MEMORANDUM

TO: Jean Fraser, Planner
FROM: David Senus, P.E.
DATE: May 1, 2015
RE: 1342 Congress Street Neighborhood Center, Preliminary Level III Site Plan Application

- Preliminary Level III Site Plan Application and attachments, dated April 3, 2015, prepared by Tighe & Bond, on behalf of the Jewish Community Alliance of Southern Maine.
- Engineering Plans, Sheets C-1 through C-9, dated April 3, 2015, prepared by Tighe & Bond, on behalf of the Jewish Community Alliance of Southern Maine.

C-2B

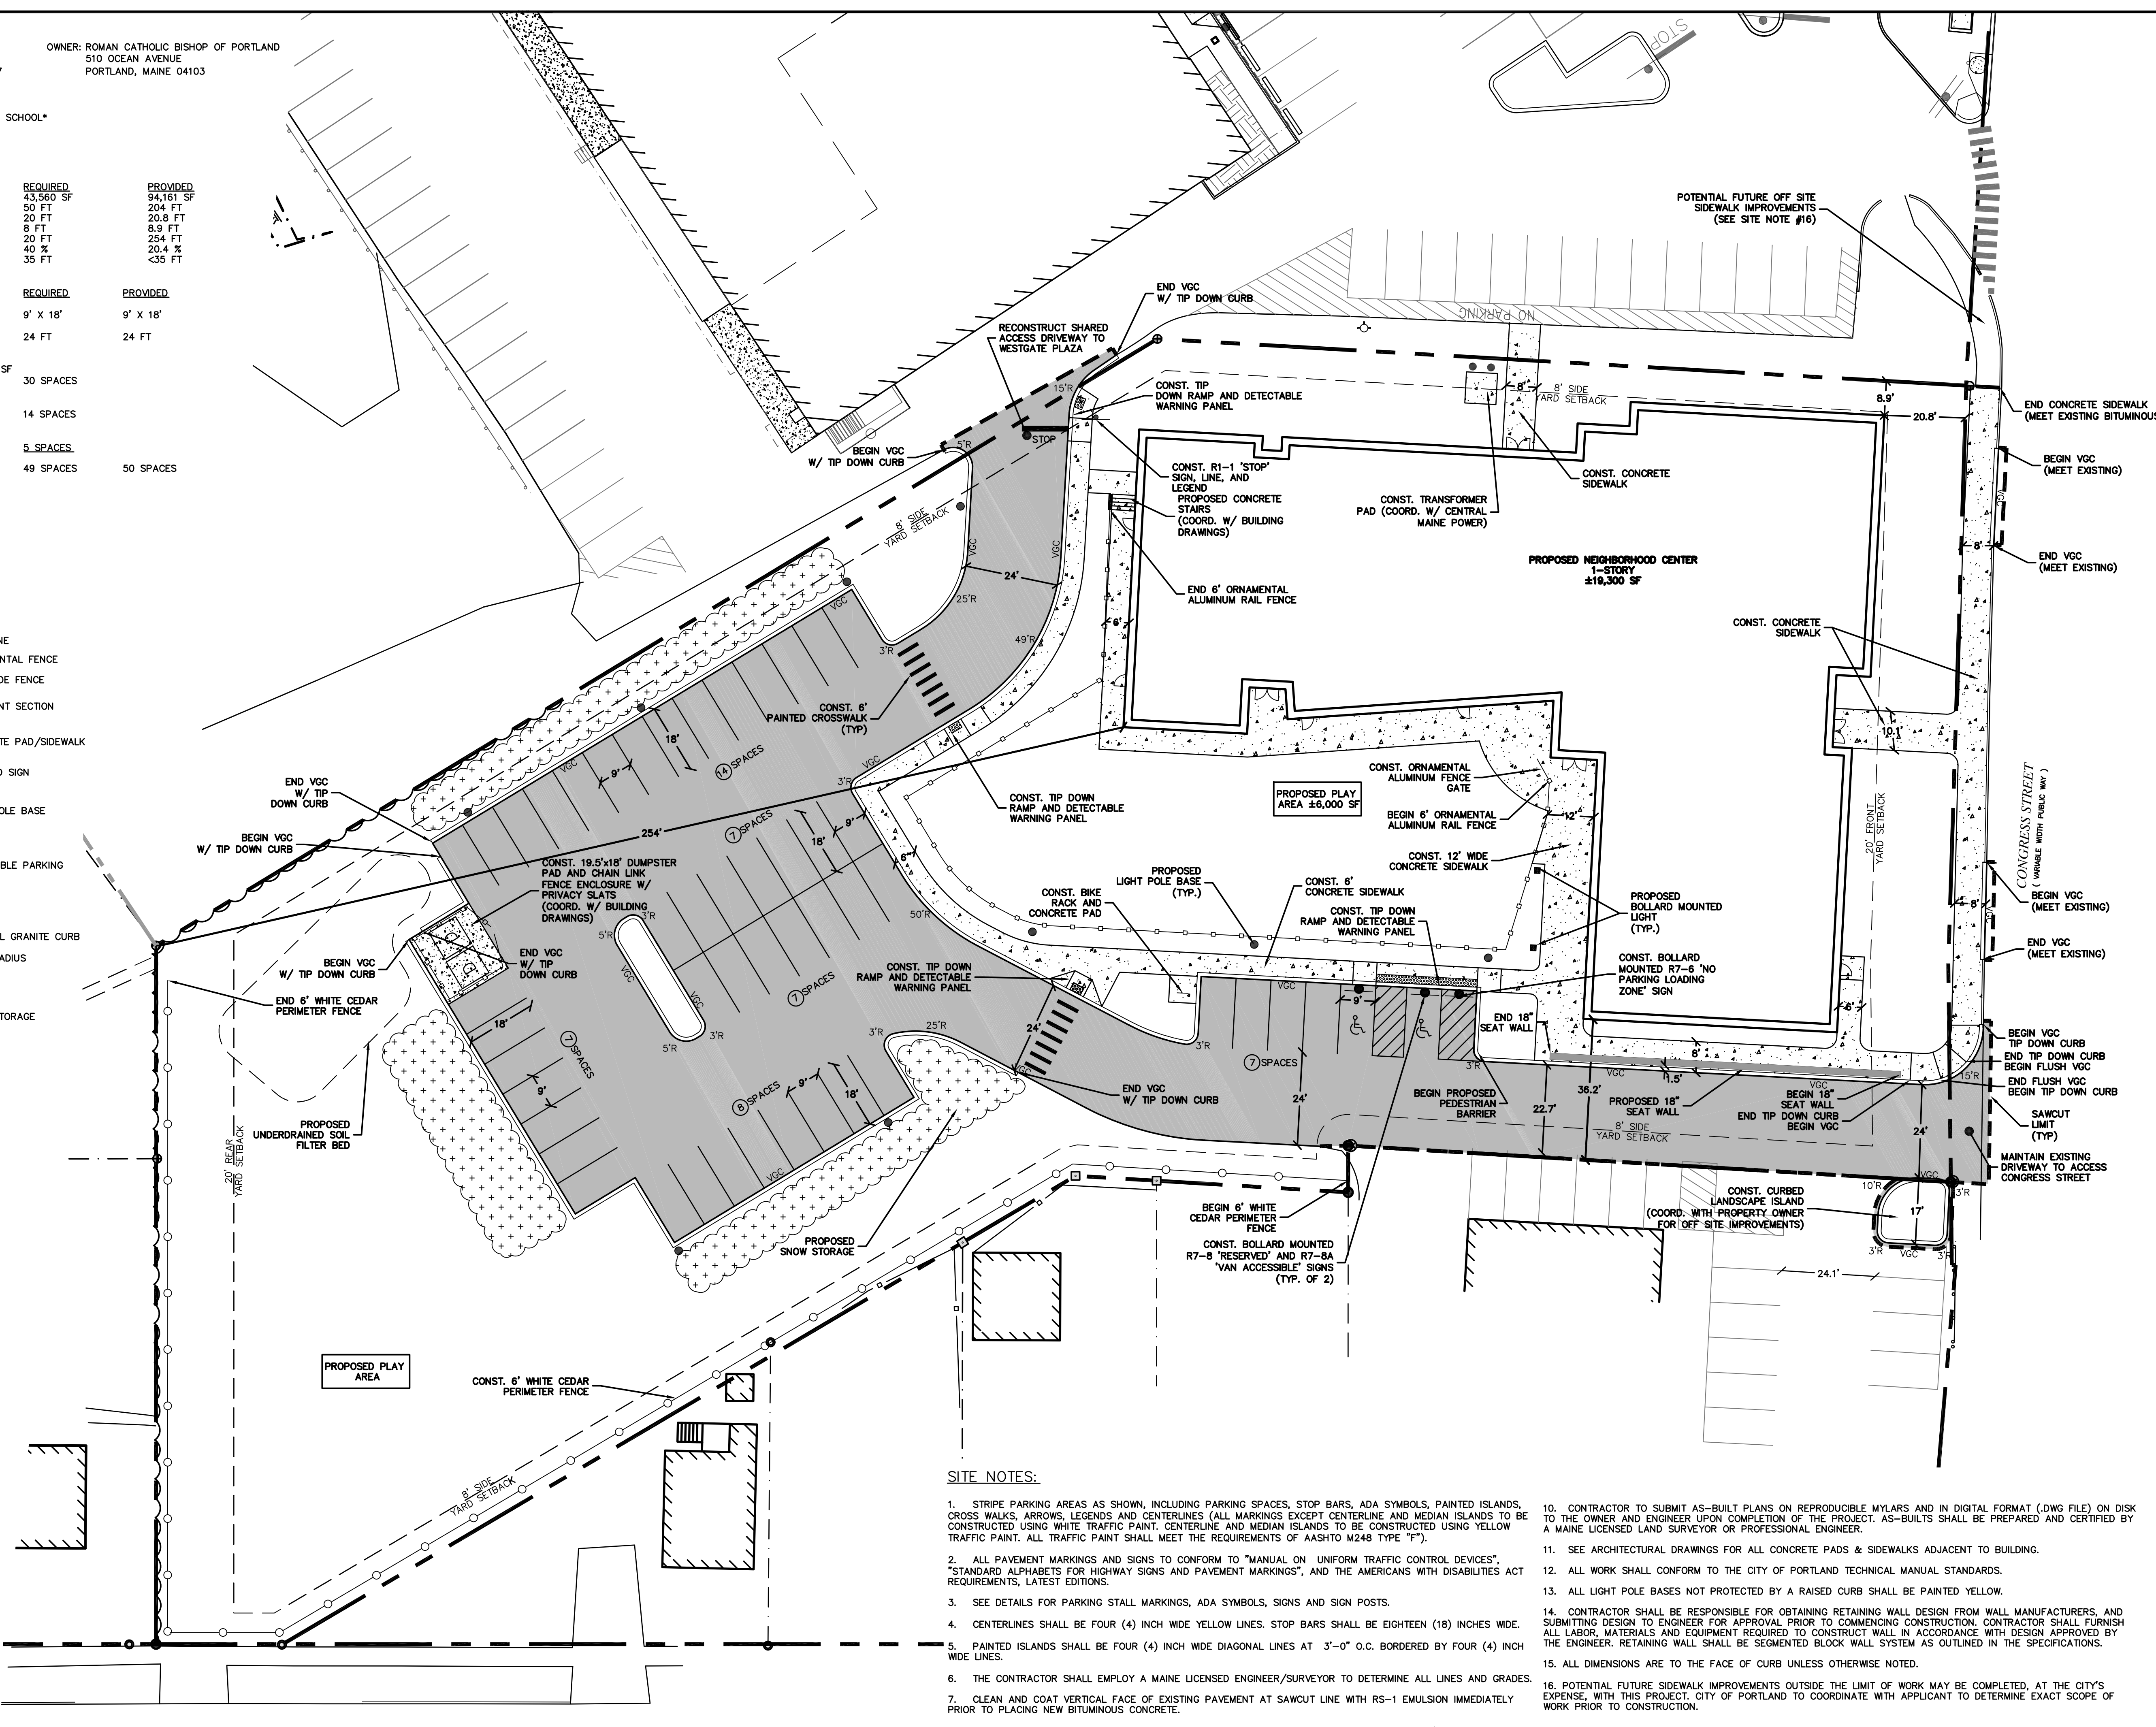
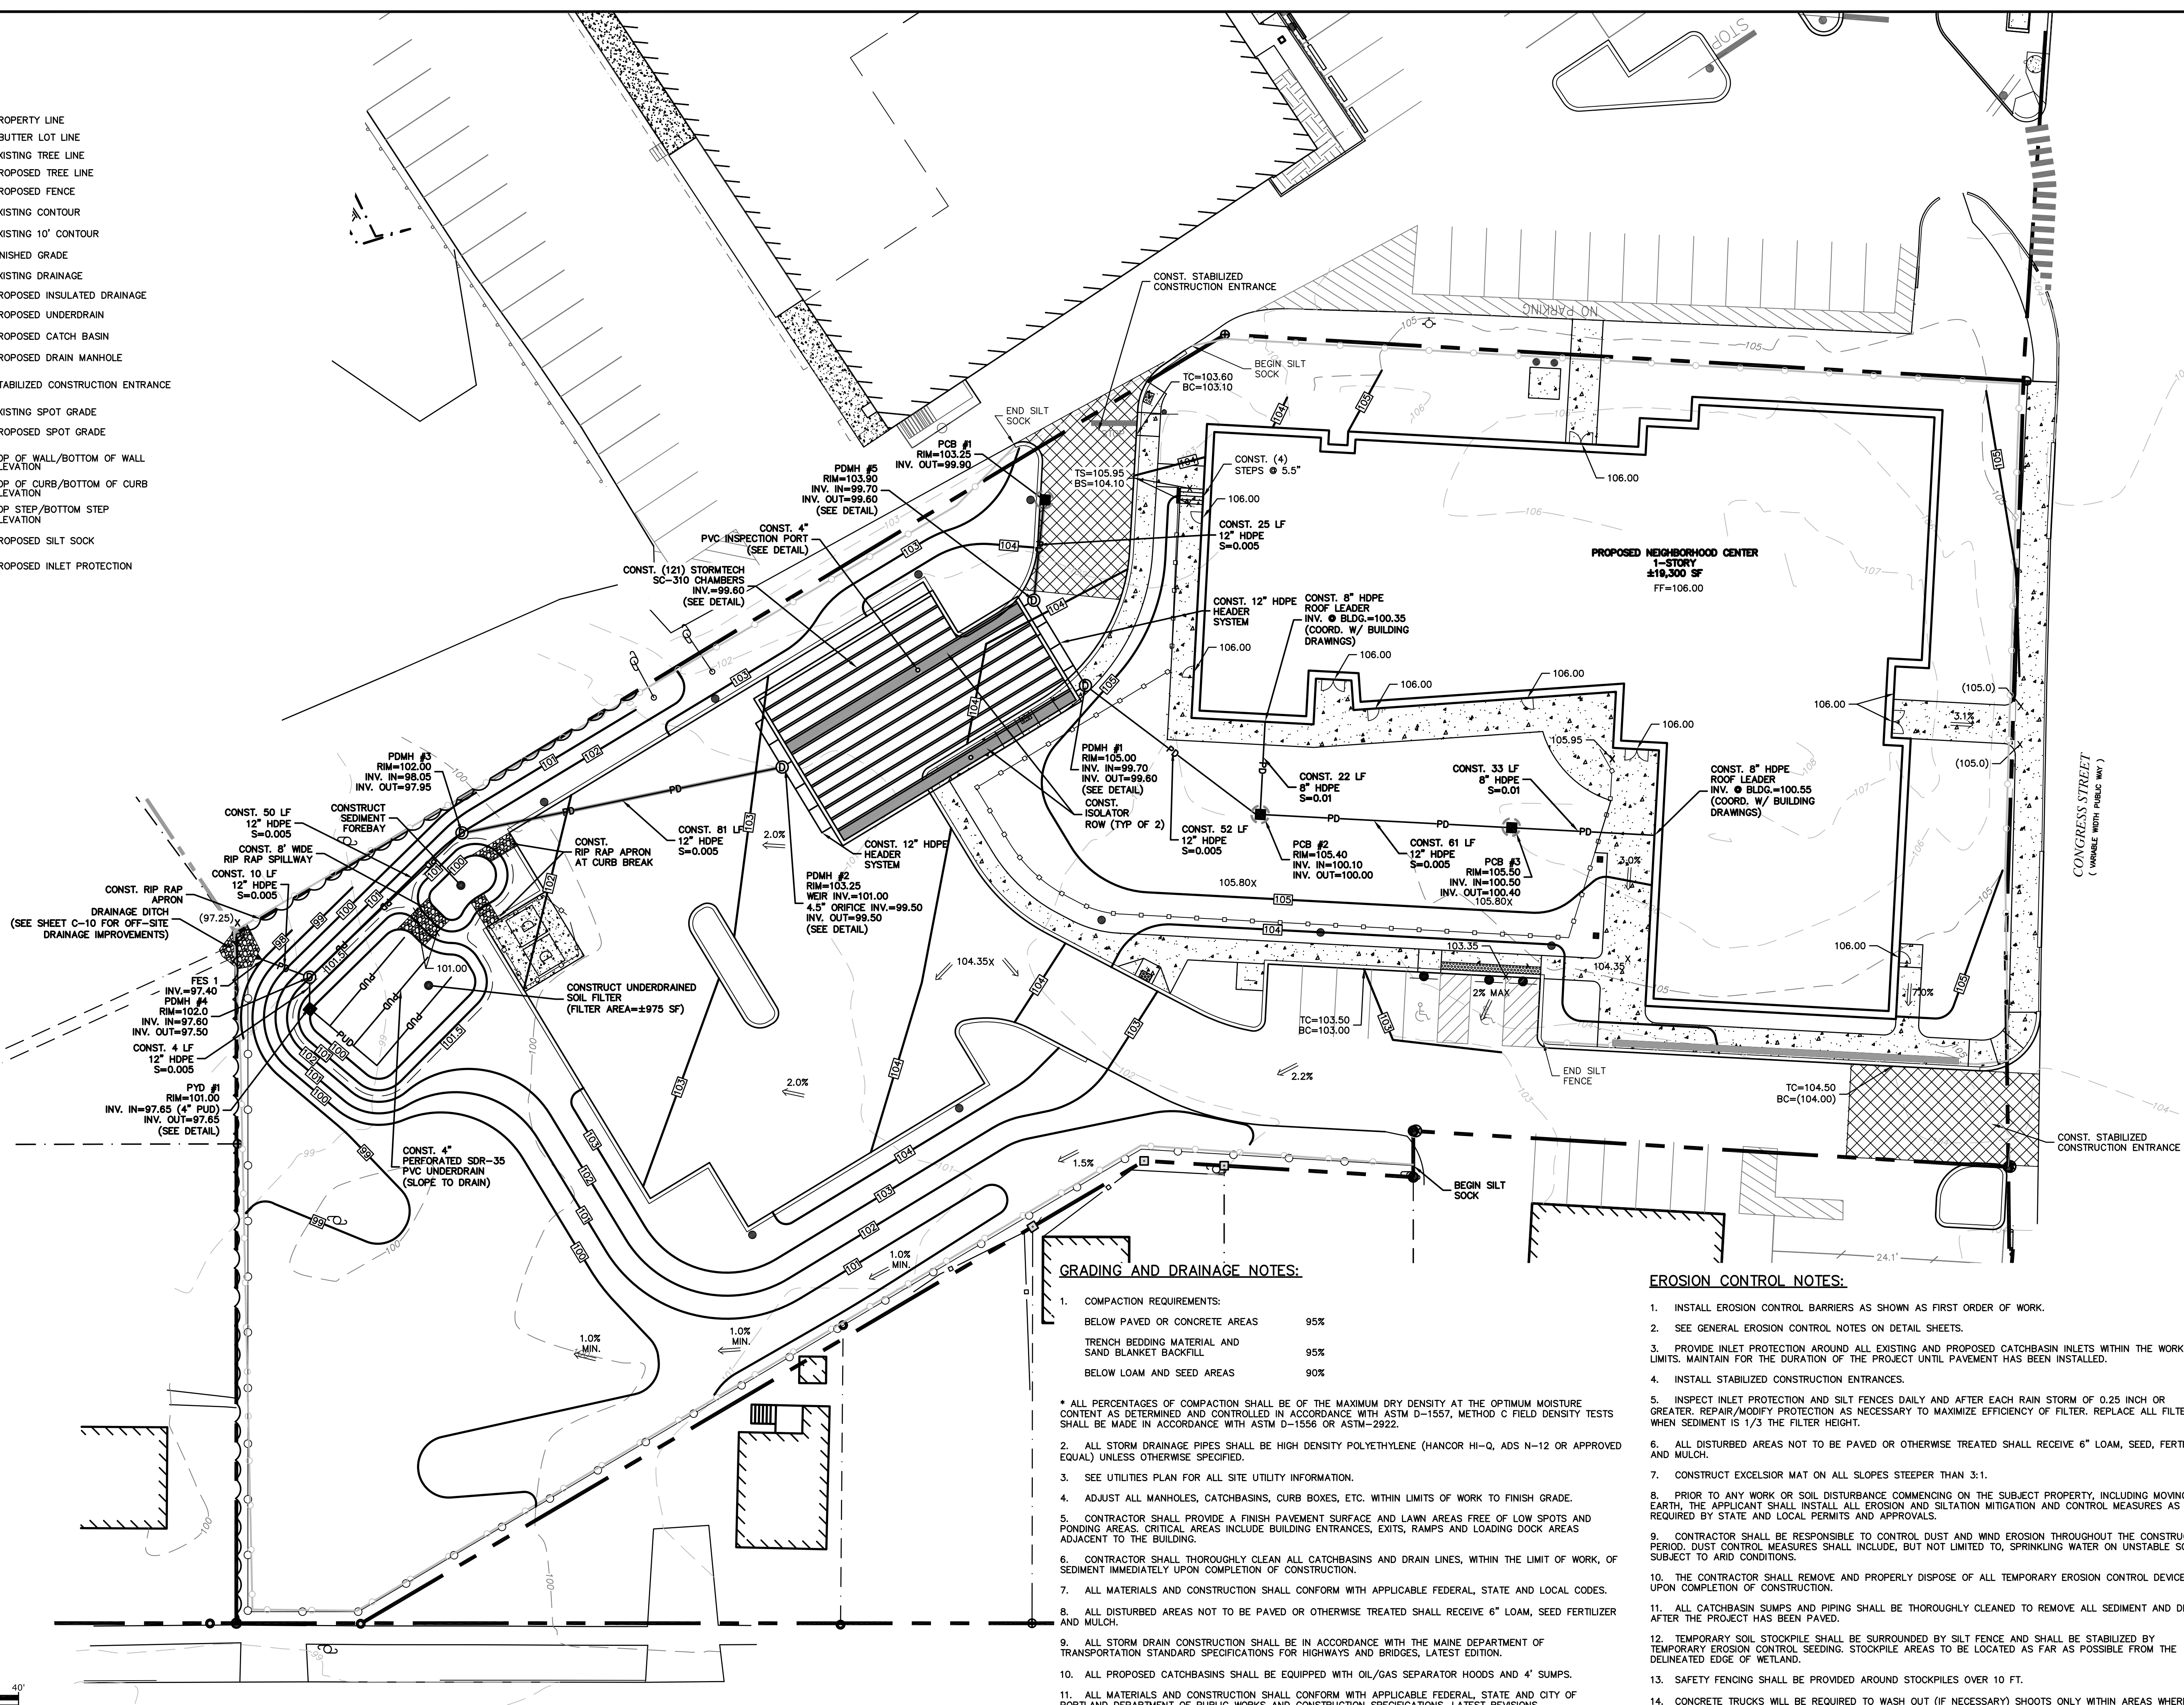
- 4) Sheet C-2b depicts snow storage along the east edge of the rear parking lot, adjacent to several residential properties. The grading plan (C-3) indicates that runoff from this area would potentially flow onto these properties. The Applicant should limit snow storage in this area and should revisit the proposed grading to ensure that runoff from the project property is not directed onto these abutting residential lots.

VERTICAL GRANITE CURB
NOT TO SCALE

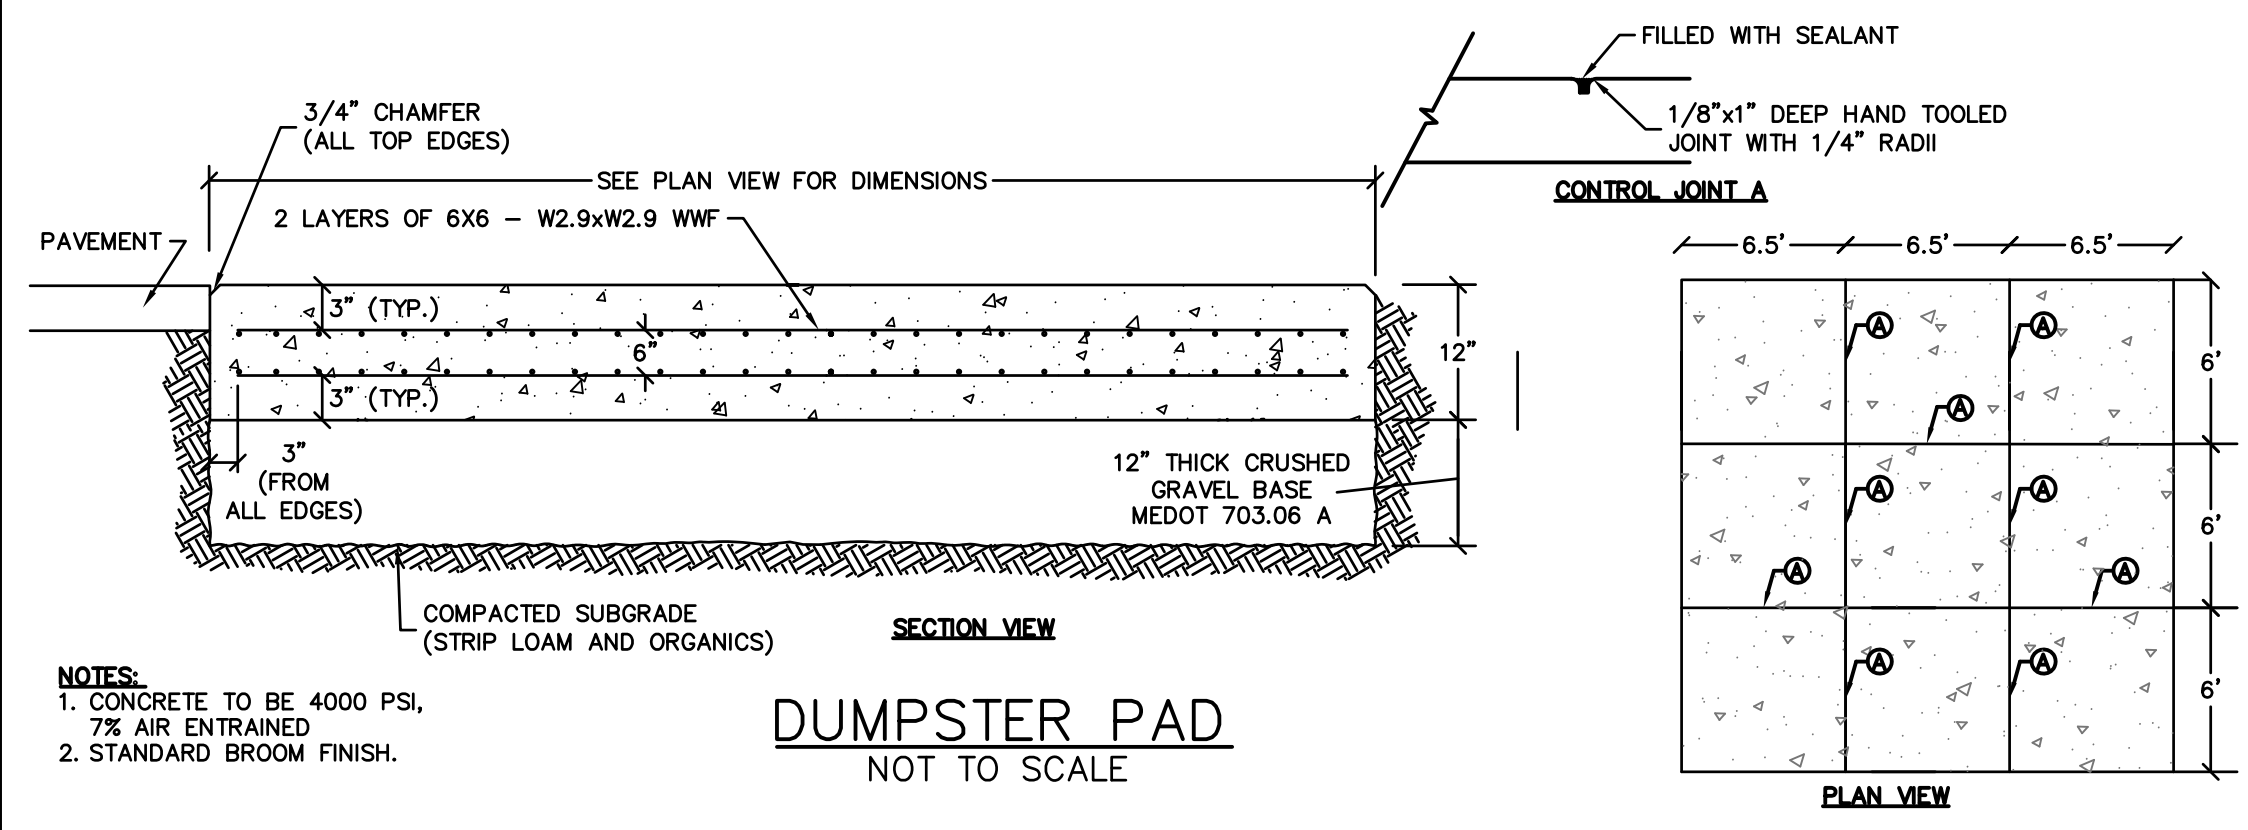
- 7) The proposed Vertical Granite Curb, Concrete Sidewalk, and Utility Trench details should be revised to comply with the City of Portland Technical Manual for work within the City Right-of-Way.

CROSS SECTION UNDERDRAINED SOIL FILTER
DETAIL
NOT TO SCALE

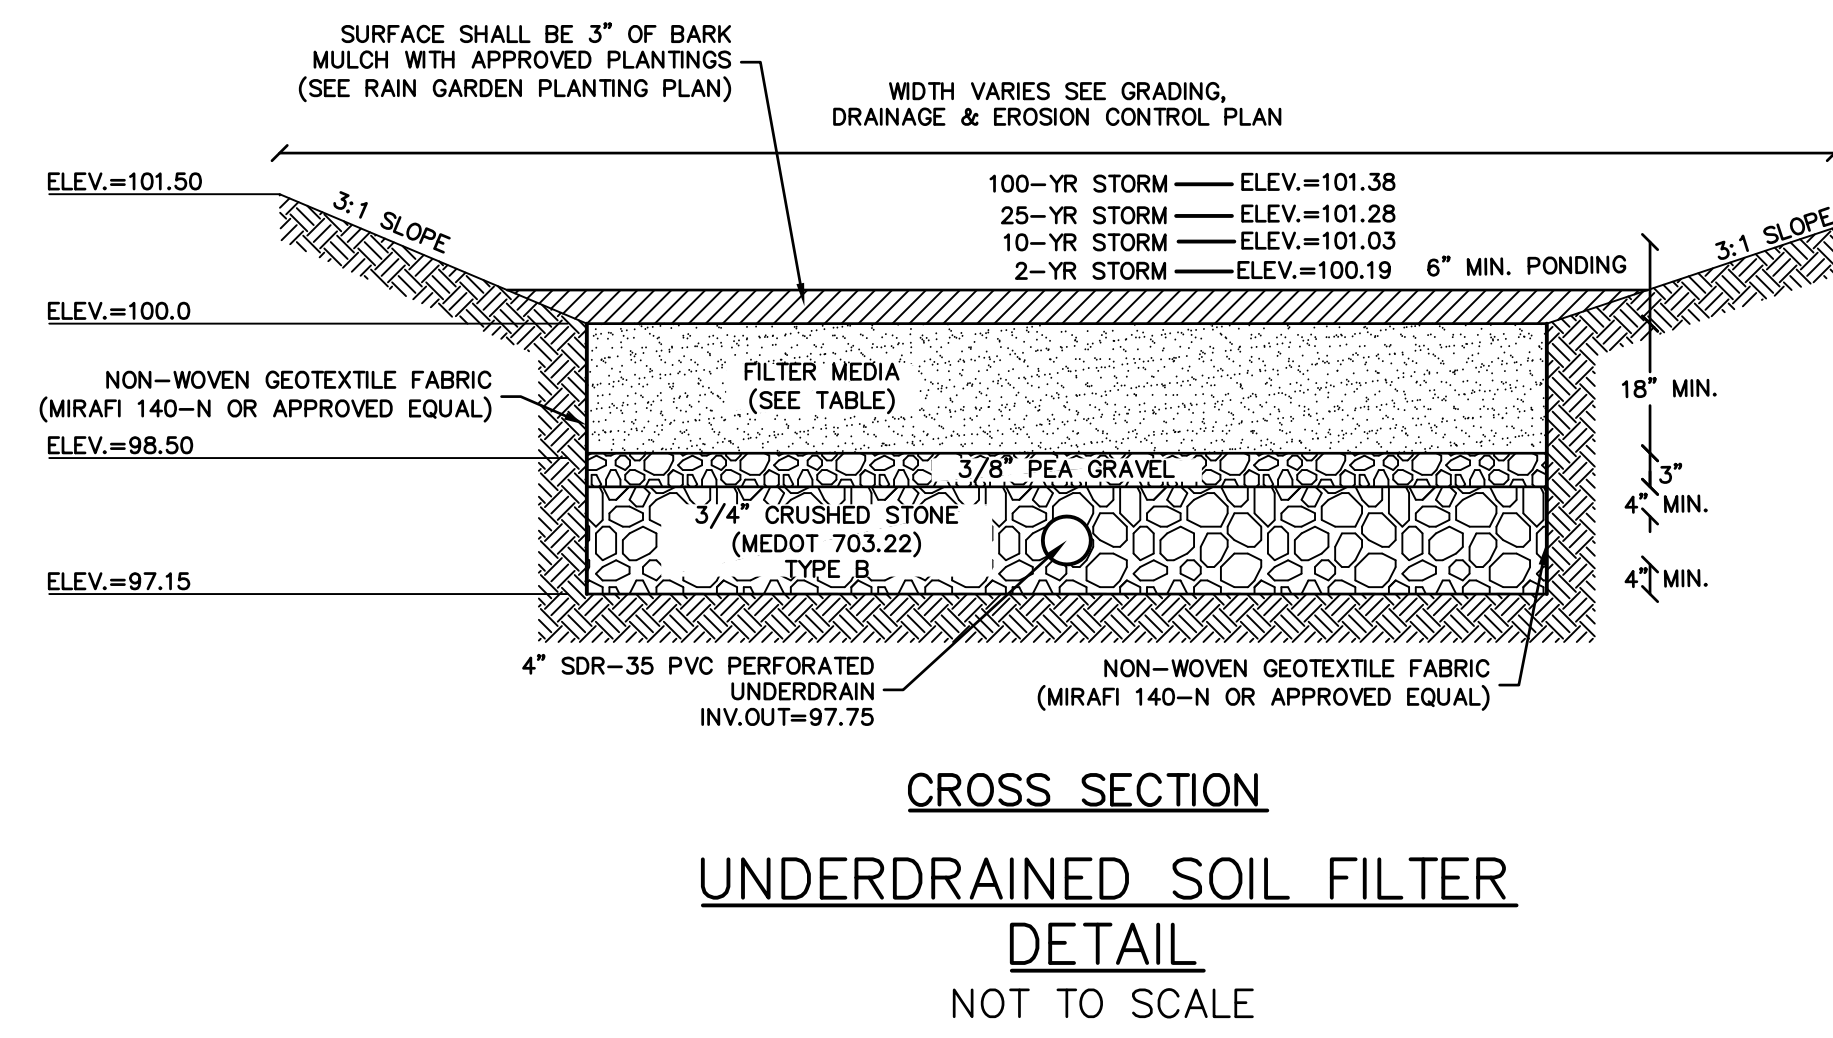
- 6) The proposed Underdrained Soil Filter Bed detail refers to a Rain Garden Planting Plan for proposed plantings; however, it does not appear that this plan has been provided at this time.
